Harnett County Government Complex
307 Cornelius Harnett Boulevard
Lillington, NC 27546

February 11, 2011

RE: Harnett County Land Use Existing Tank Application #11-5-26019

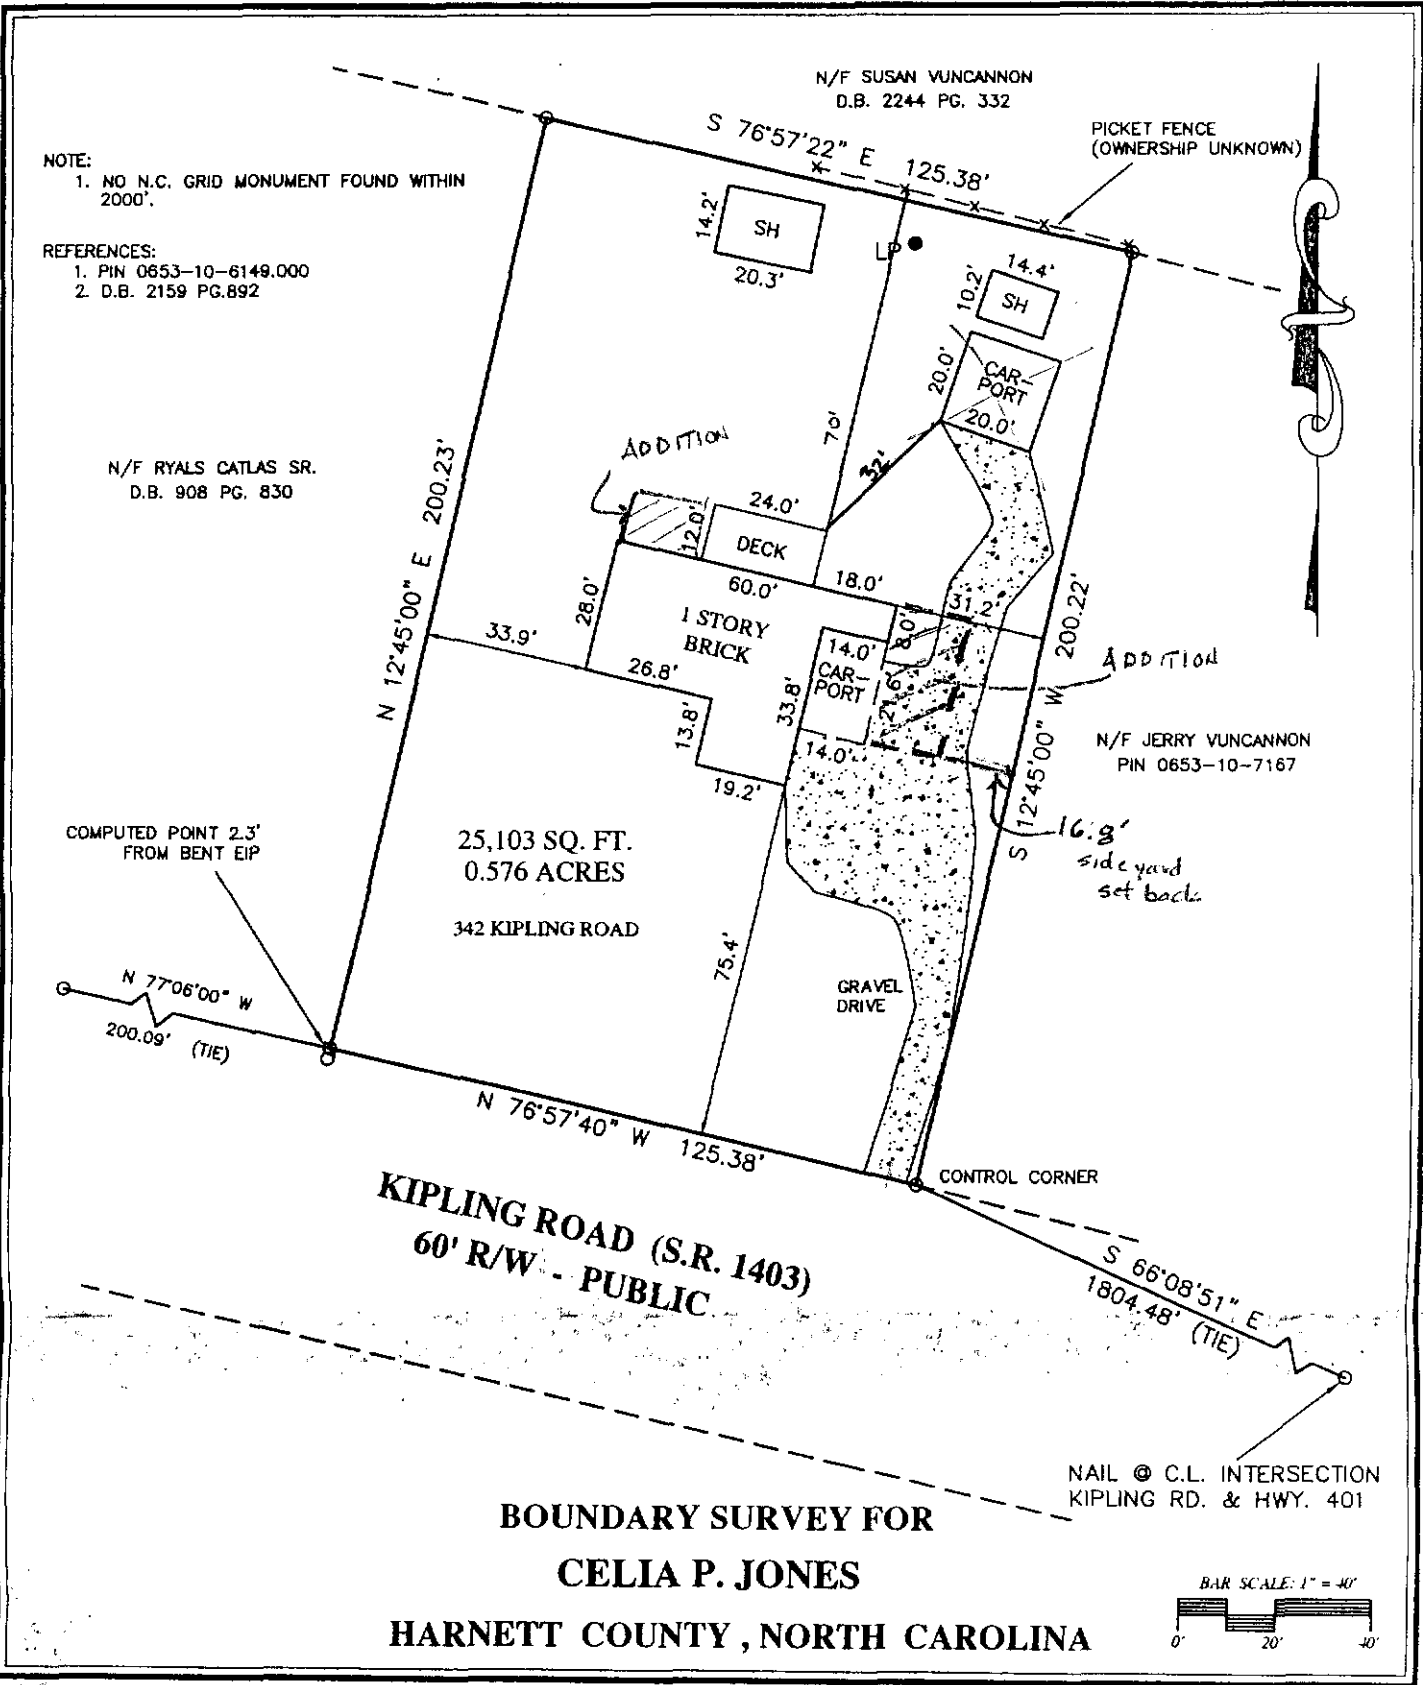
Based on the criteria set out in Title 15A, Subchapter 18A, of the North Carolina Administrative Code, Rules .1950, the evaluation indicated that the site is **UNSUITABLE** for the addition requested. Therefore, your request for an existing tank is **DENIED**. The site is denied based on the following:

- _____ 15A NCAC 18A.1950a {16} - Any swimming pool must be 15' from any part of septic system.
- _____ 15A NCAC 18.1945{b} - Each lot shall have original septic system plus repair area.
- X 15A NCAC 18A.1950 {10} - Any building to be 5' from drain line.
- _____ 15A NCAC 18A.1950{c} - Nitrification fields and repair areas shall not be located under paved areas or areas subject to vehicular traffic.

Please contact me to discuss the need to locate your drain field and your options available to you. If you should have any questions or concerns, *I can be contacted Monday through Friday from 8am – 9am at 910-893-7547.*
